**City of Portland, Maine - Building or Use Permit Application**  
 389 Congress Street, 04101 Tel: (207) 874-8703, Fax: (207) 874-8716

<b>Permit No:</b> 06-1761	<b>Issue Date:</b>	<b>CBL:</b> 238A B004001
------------------------------	--------------------	-----------------------------

<b>Past Use:</b> Commercial	<b>Proposed Use:</b> Commercial renovation of 3500sf medical office space	<b>Permit Fee:</b> \$2,010.00	<b>Cost of Work:</b> \$198,425.00	<b>CEO District:</b> 3
<b>Proposed Project Description:</b> Renovations of 3500 medical office space		<b>FIRE DEPT:</b> <input type="checkbox"/> Approved <input type="checkbox"/> Denied	<b>INSPECTION:</b> Use Group: Type	
		Signature:	Signature:	
<b>PEDESTRIAN ACTIVITIES DISTRICT (P.A.D.)</b>				
Action <input type="checkbox"/> Approved <input type="checkbox"/> Approved w/Condition <input type="checkbox"/> Denied				
Signature: Date:

1 LIFE SAFETY PLAN
LSP1 Scale: 1/4" = 1'-0"

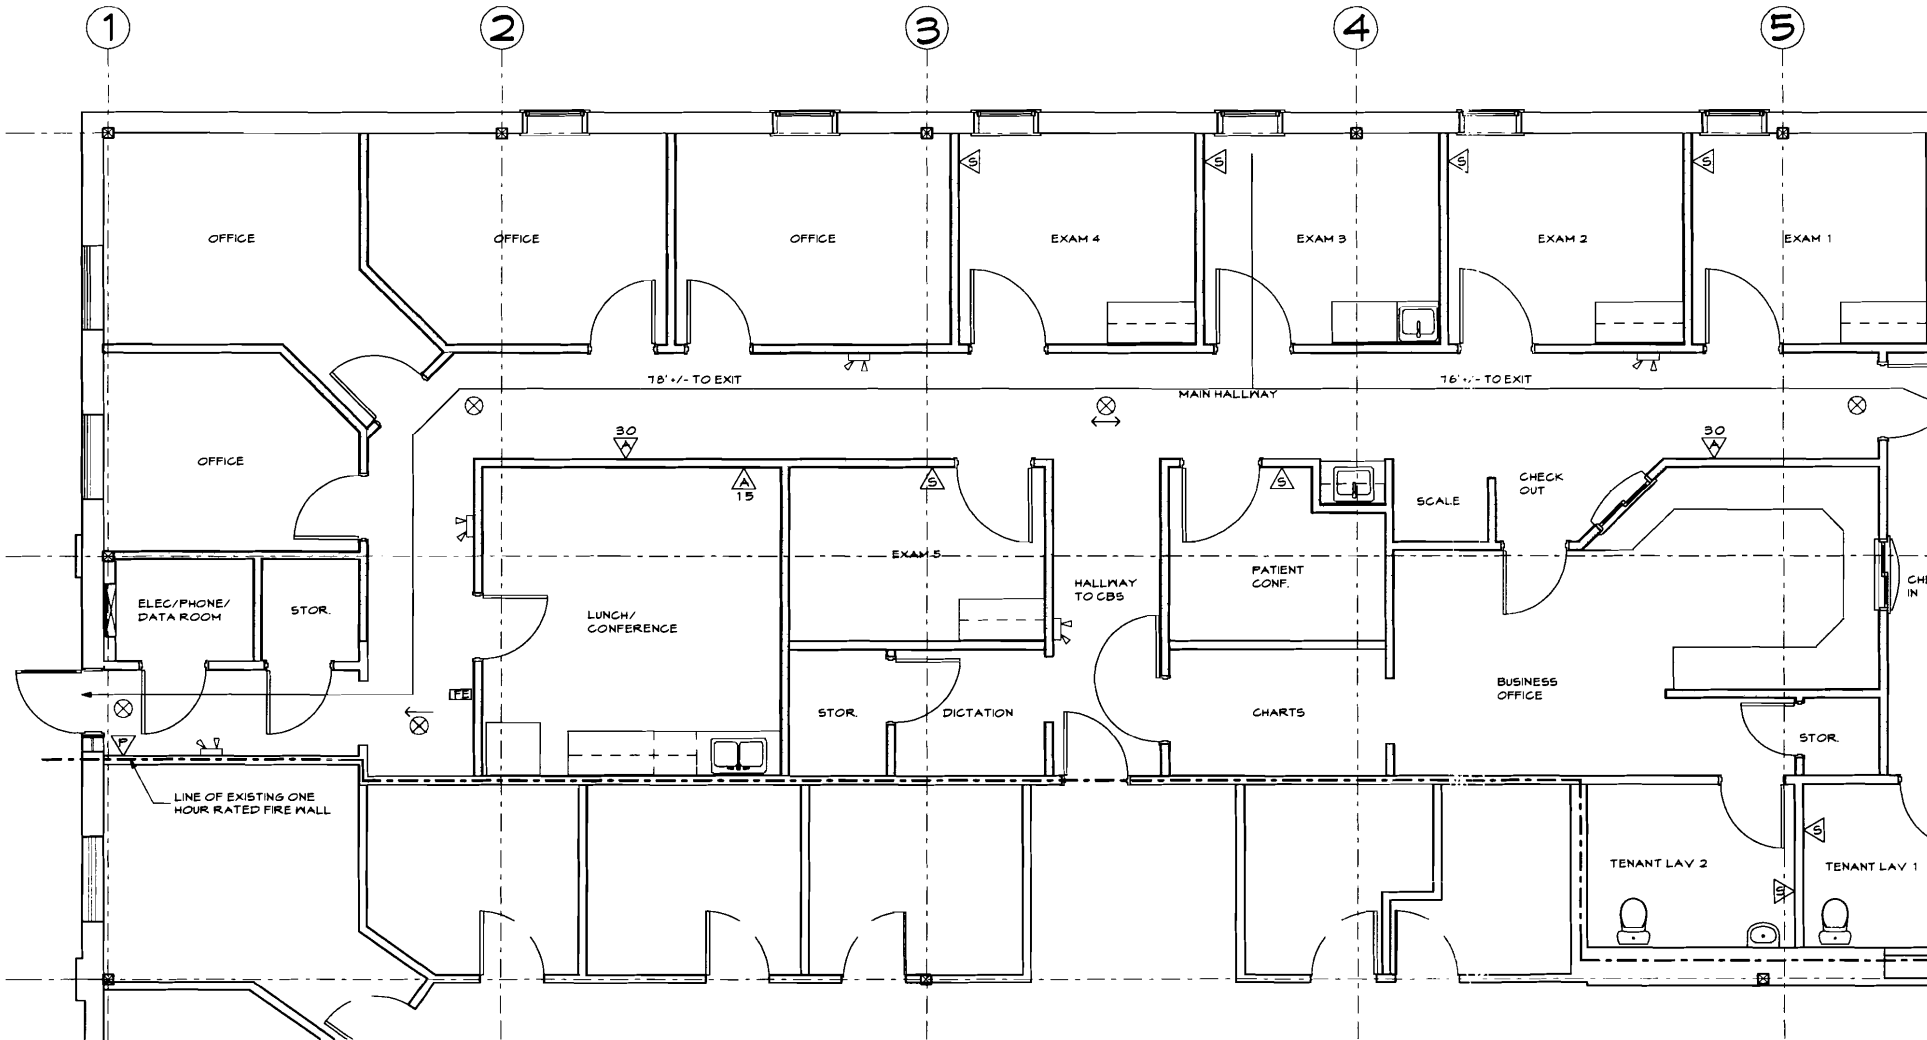
1) This permit is approved with the design revision keeping both bathrooms available for public access.			
2) All existing fire separations must remain intact and penetrations must be sealed.

<b>Comments:</b>
1/11/2007-jmb: Left voice msg. W/Anne C. For info on pre-existing layout and fixture count calculation
1/16/2007-jmb: Anne C. Called to refer to page A1.2 for the existing large room layout. She will fax a change for both bathrooms to be available for public use, essentially removing the storage closet to create a hall, page LSP1.
1/16/2007-jmb: Received revisions, ok to issue
